Subject: RE: 14-136 Pearl Dental, Angmering

The proposal results in a substantial alteration to the property which is a key property within the Angmering Conservation Area.

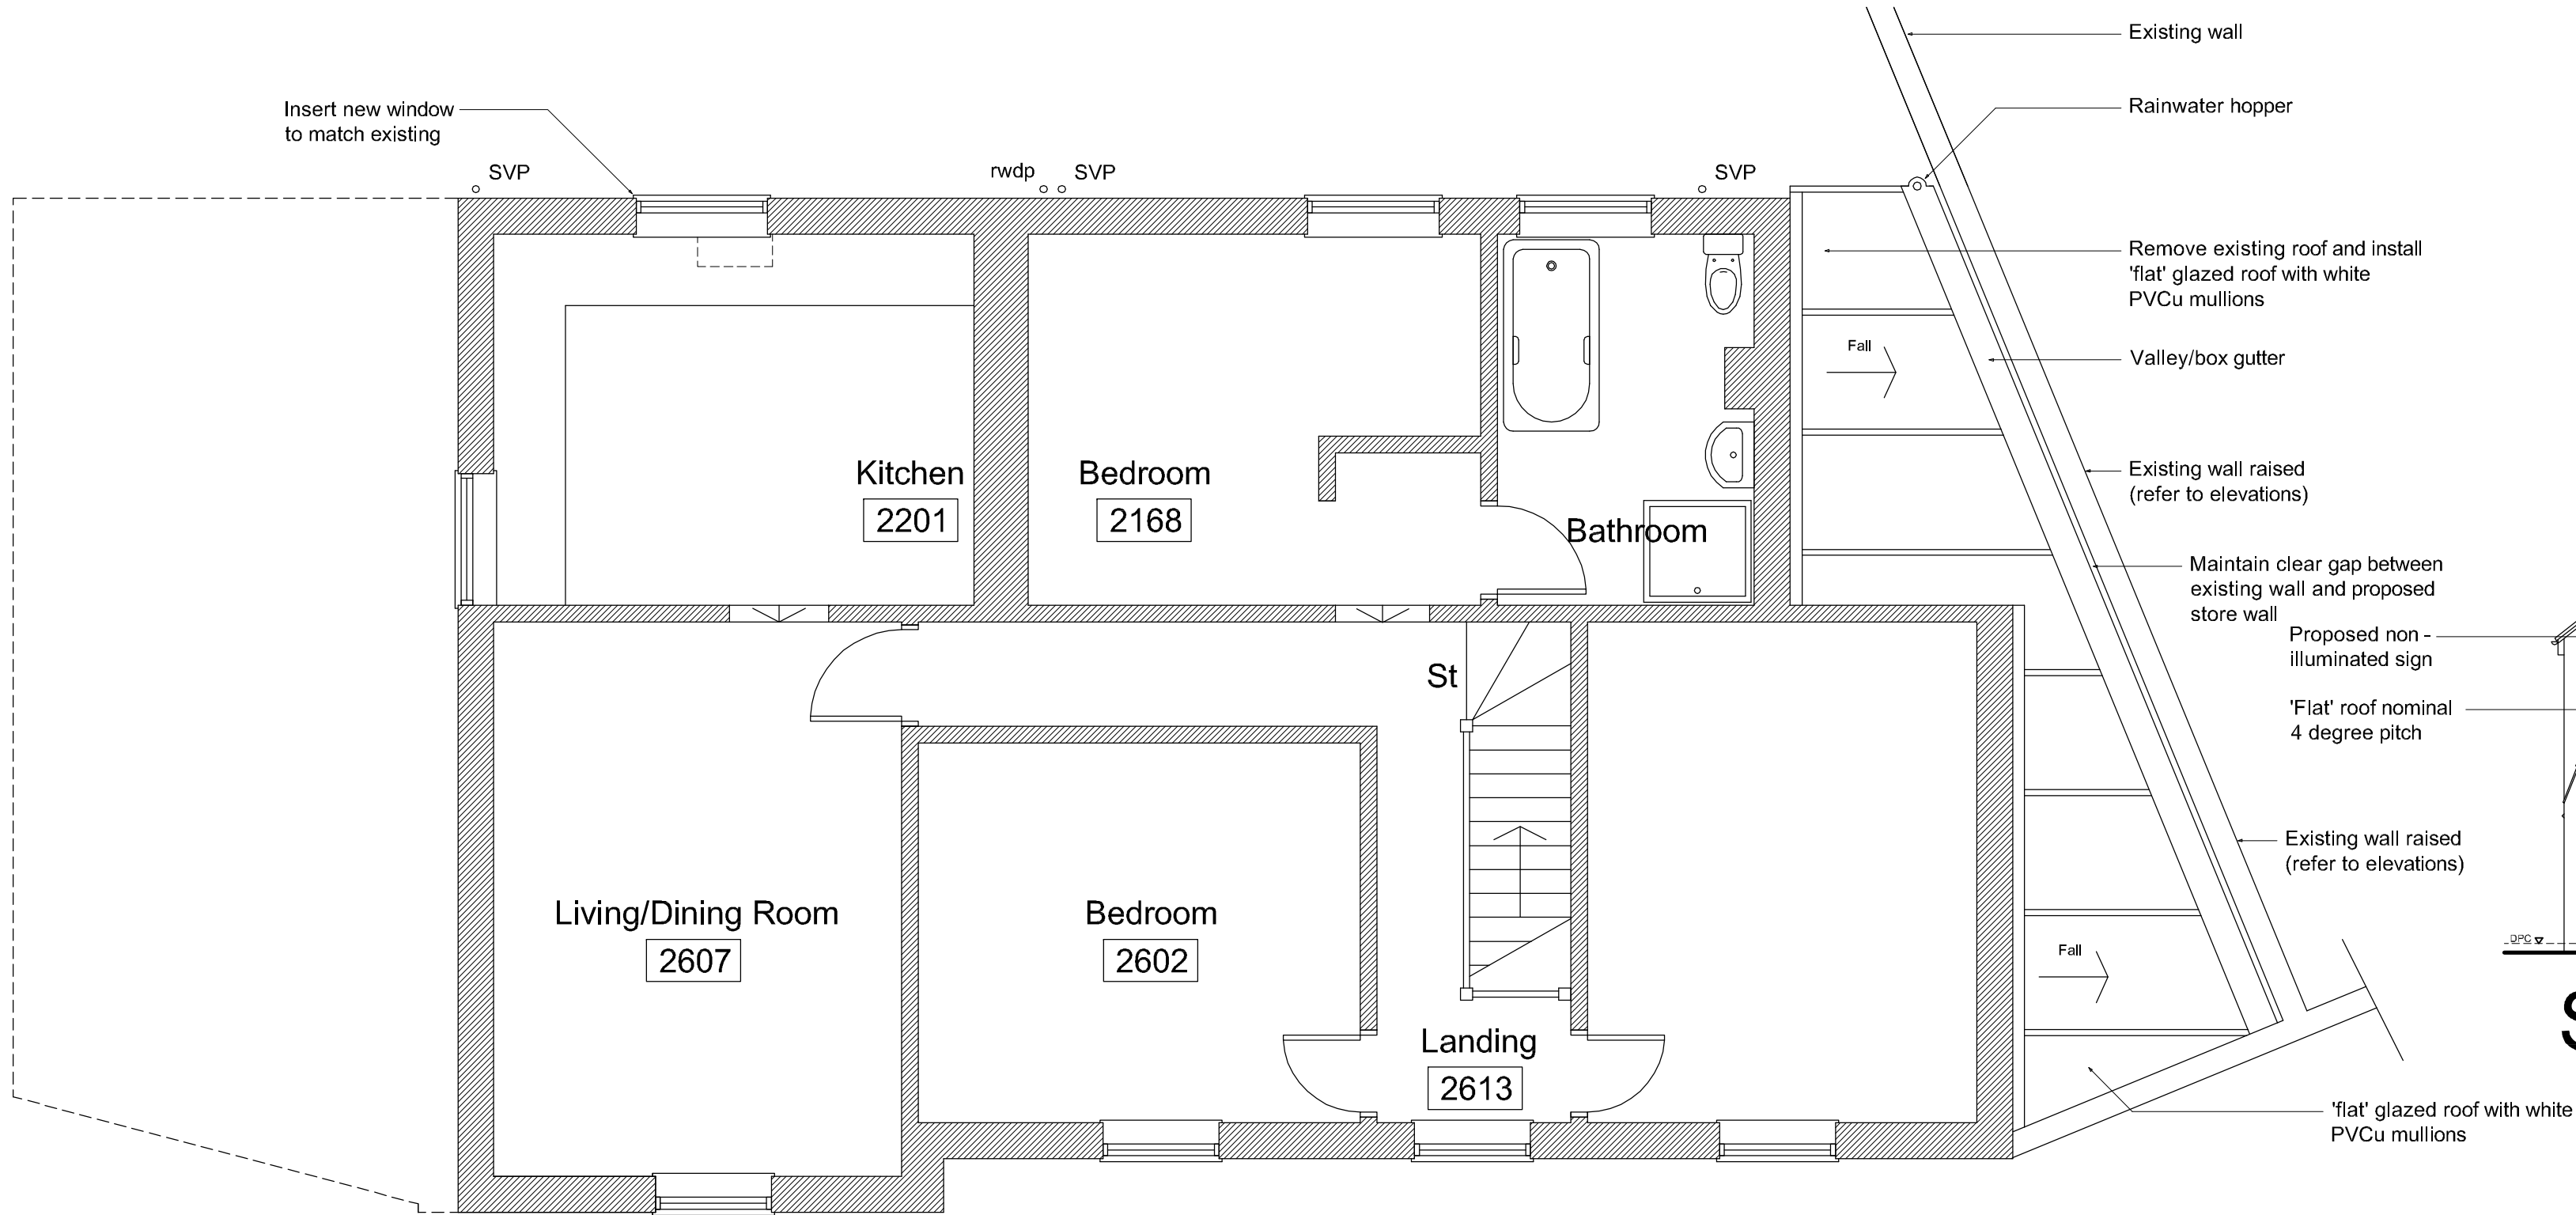
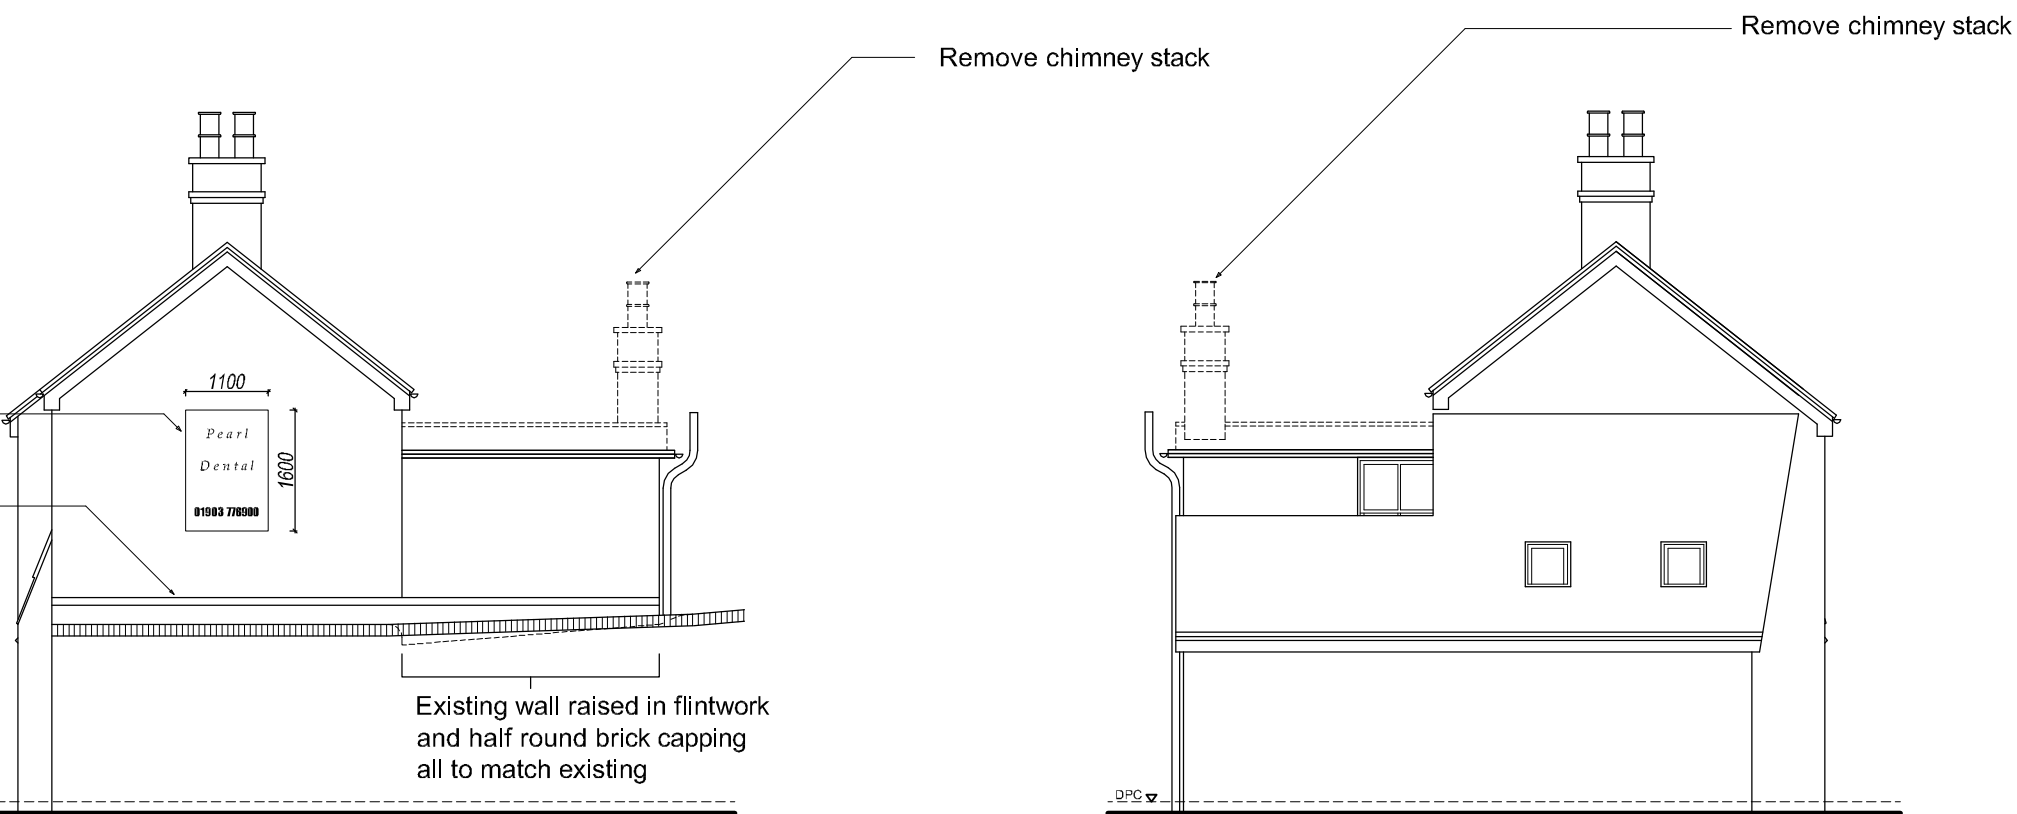
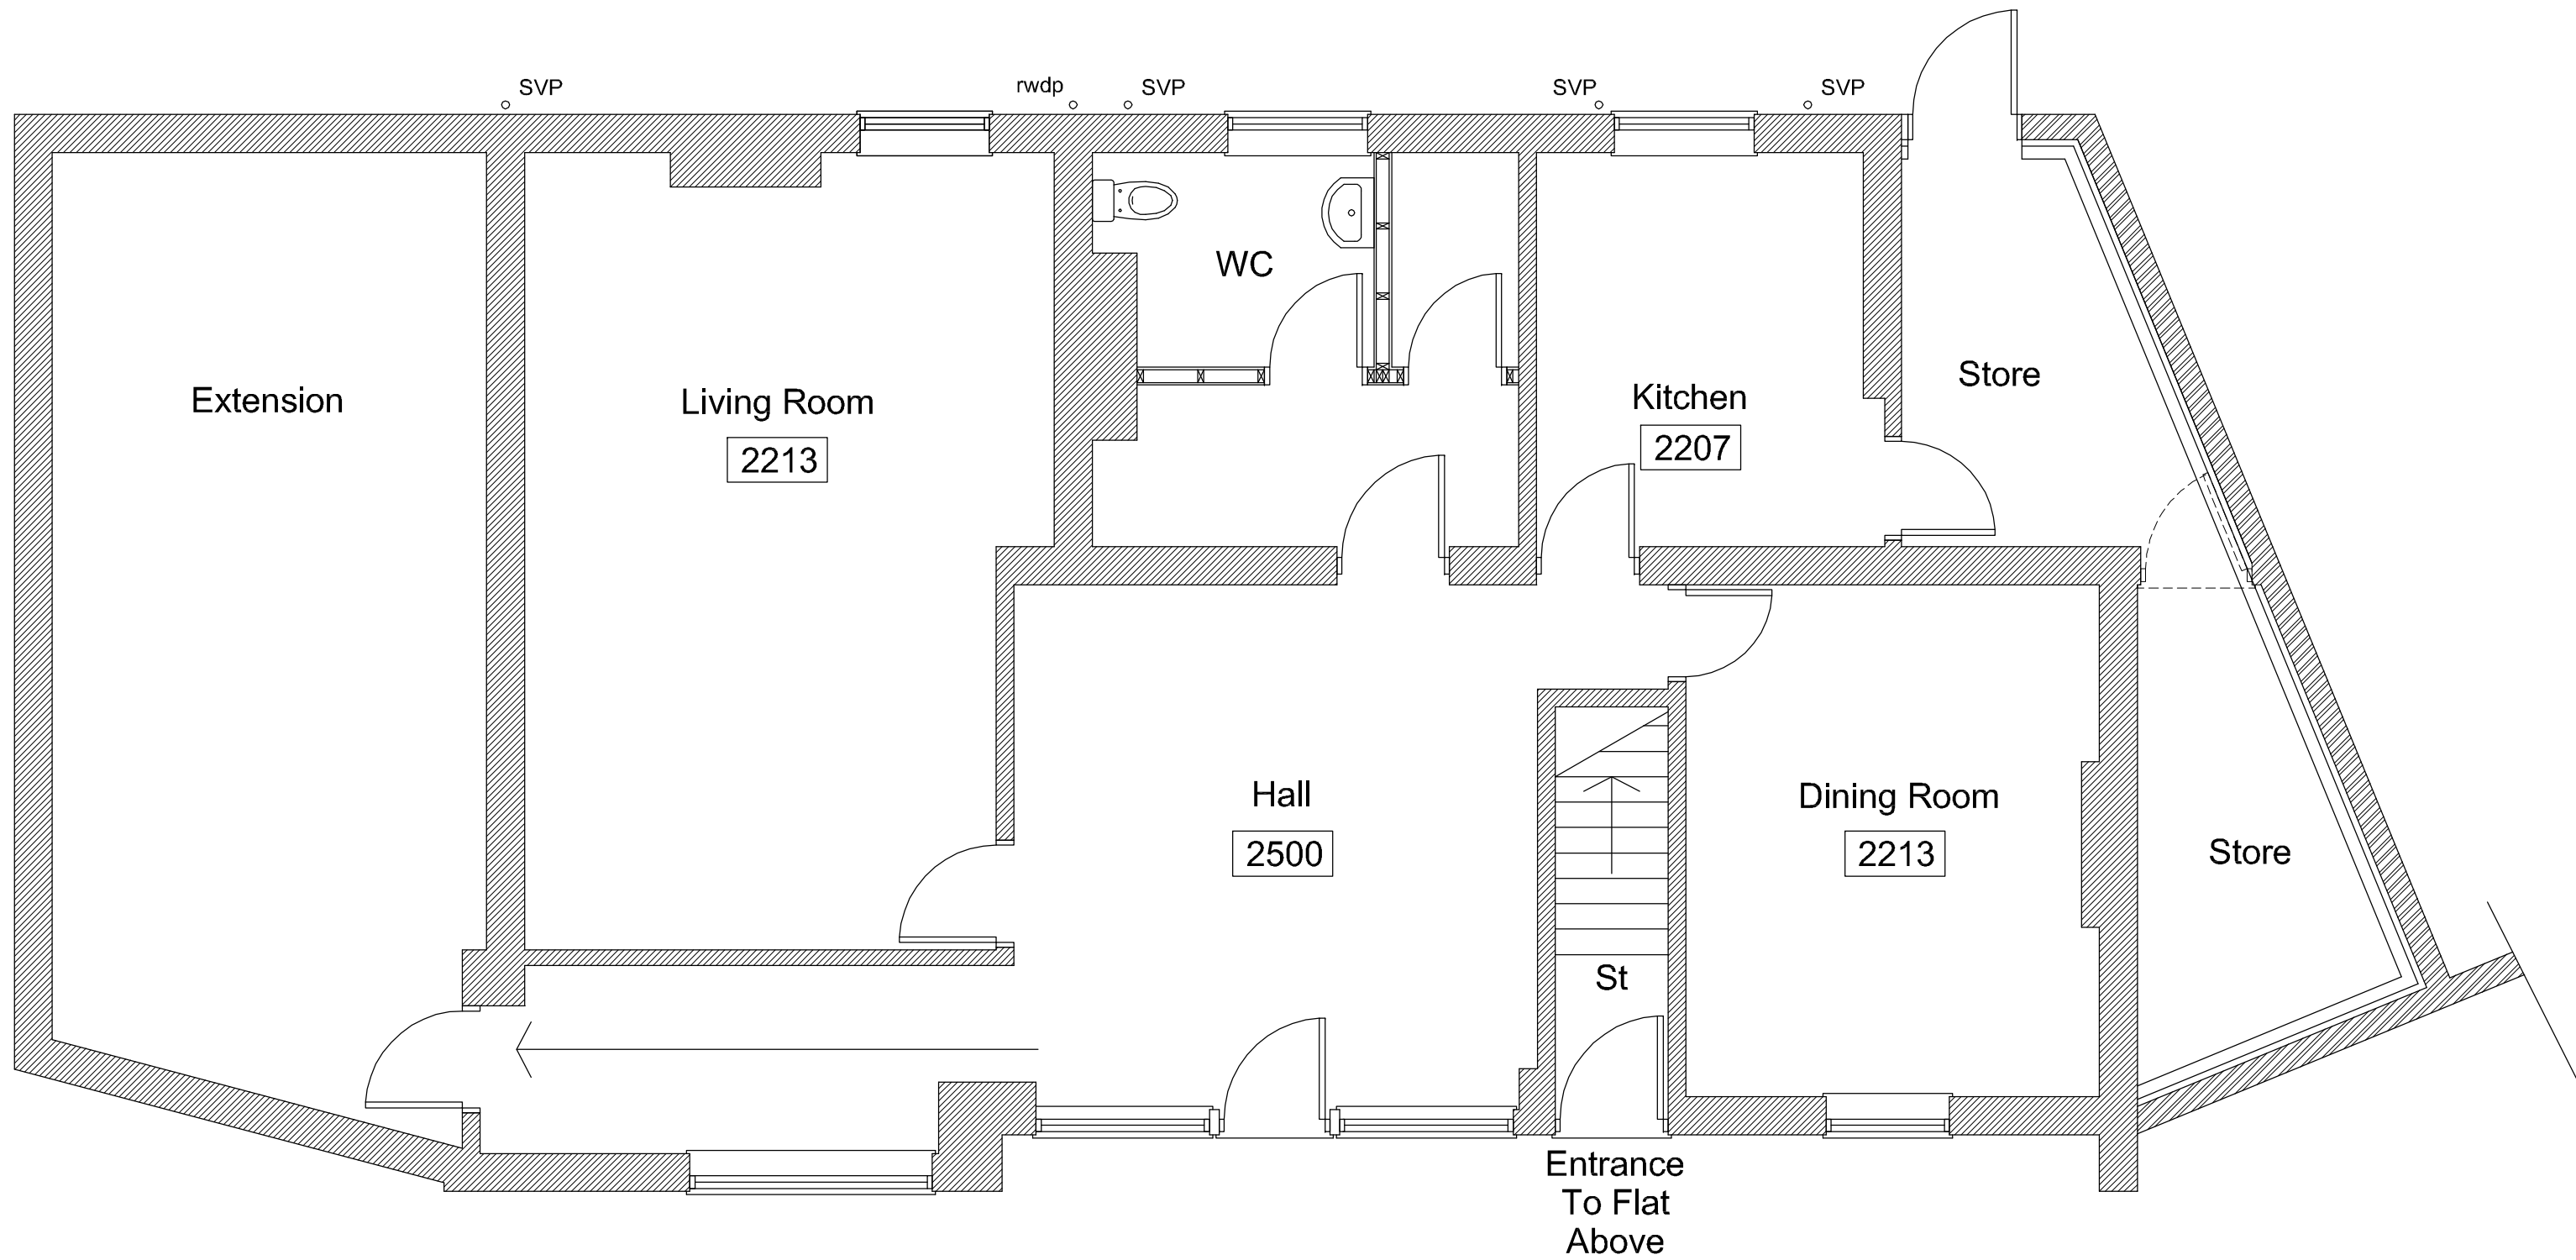
The shape, height and variety of chimney stacks and other architectural details on buildings in a conservation area such as this contribute greatly to the local character and should be retained and repaired. The removal of the chimney stacks (especially the main stack), would have a negative impact on the appearance of the property, and on the rest of the square. Such a loss cannot be supported.

The roof is one of the most important parts of a property as it can bring harmony to a townscape. Where possible, the original roof material (such as natural slate should be retained and repaired, or replaced on a like-for-like basis. Imitation slates and pantiles are a poor substitute in quality and appearance for natural slate and detract from the character of a building, and cannot be supported.

Timber eaves, fascias and bargeboards can also contribute significantly to the character and appearance of the roof and should be retained and maintained. Looking at the pictures provided, it is clear that the proposal would lead to the loss of such features at the rear of the property.

The loss of the roof plan would also be problematic, as it appears to be an original feature of the property. Can an alternative option be considered which would retain more historic fabric/appearance?

Can it be confirmed if the replacement/new flat roof would be visible from the front elevation. At the moment, the side elevation appears to identify that the flat roof would appear above the of the front walling
